Re: 1441 Woodward SE – Retaining Wall Evaluation - Follow up

**RE: Property located at 1441 Woodward Rd. SE
Albuquerque, NM 87106
Retaining wall concerns
File: M15D23B**

**Re: Candlewood Suites, Lot 2-A Sunport Park Grading and Drainage Plan
Engineer's Stamp dated 6-18-08, (M15/D23B)**

RE: CONCEPTUAL DRAINAGE PLAN FOR FRONTIER SYSTEMS, INC. (M-15/D23B)
ENGINEER'S STAMP DATED JUNE 4, 1990 RECEIVED JUNE 4, 1990

DRAINAGE AND GRADING PLAN
 CANDLEWOOD SUITES
 LOT 2-A-3, BLOCK 4-B, SUNPORT PARK
 FOR: KAREEM KASAM

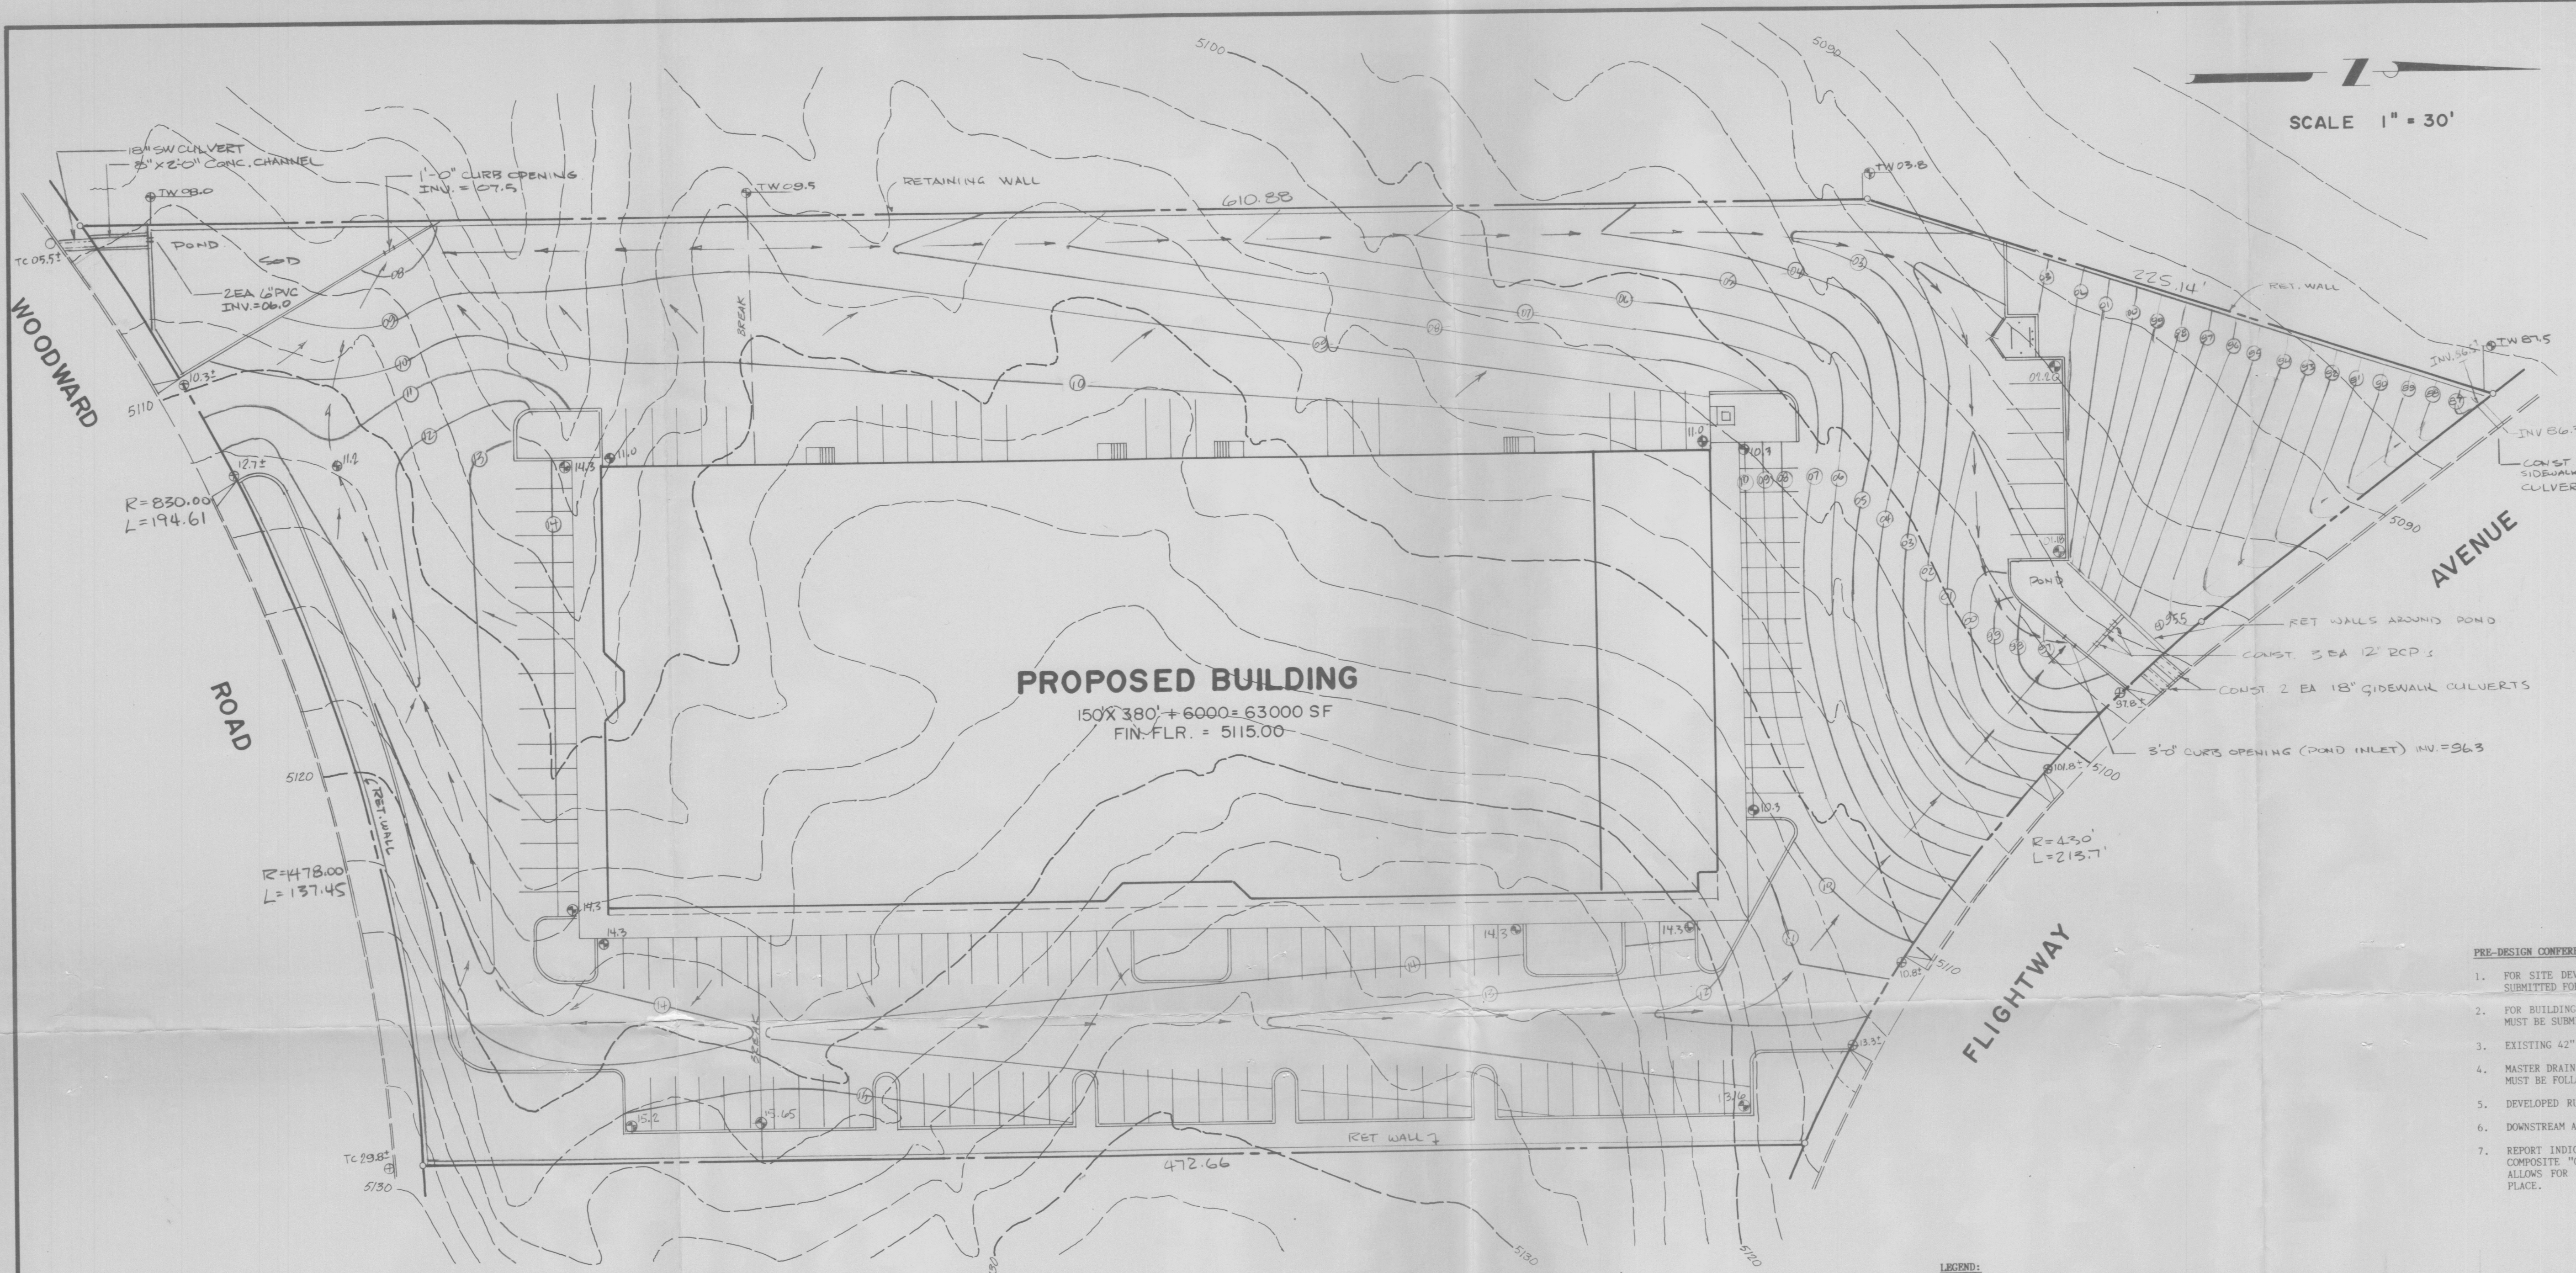
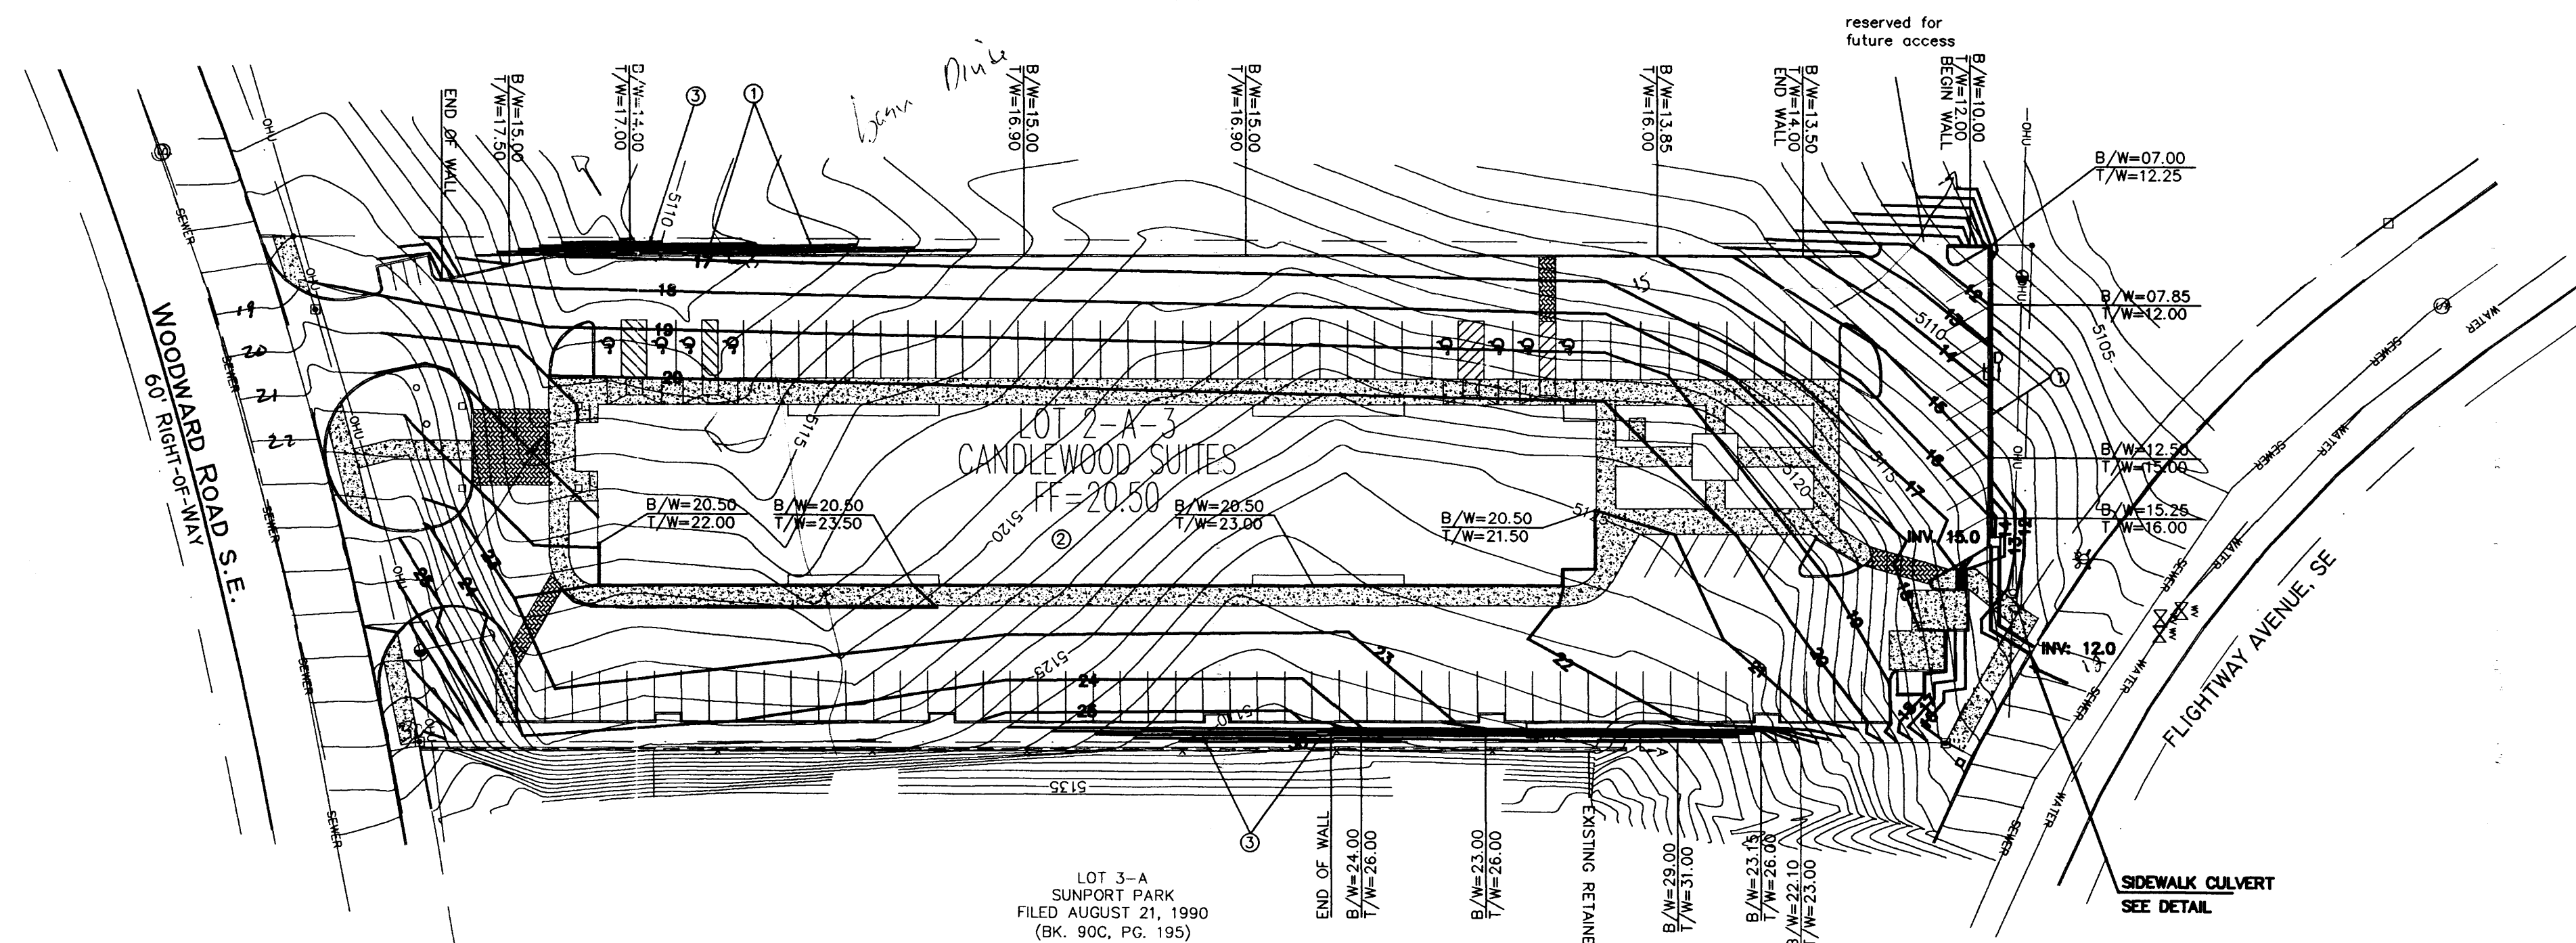
- a conceptual plan addressing all lots created in the plat should included in order to adequately design any retaining walls needed.
- How will the runoff programmed to go Lot 2-A-2 be addressed.
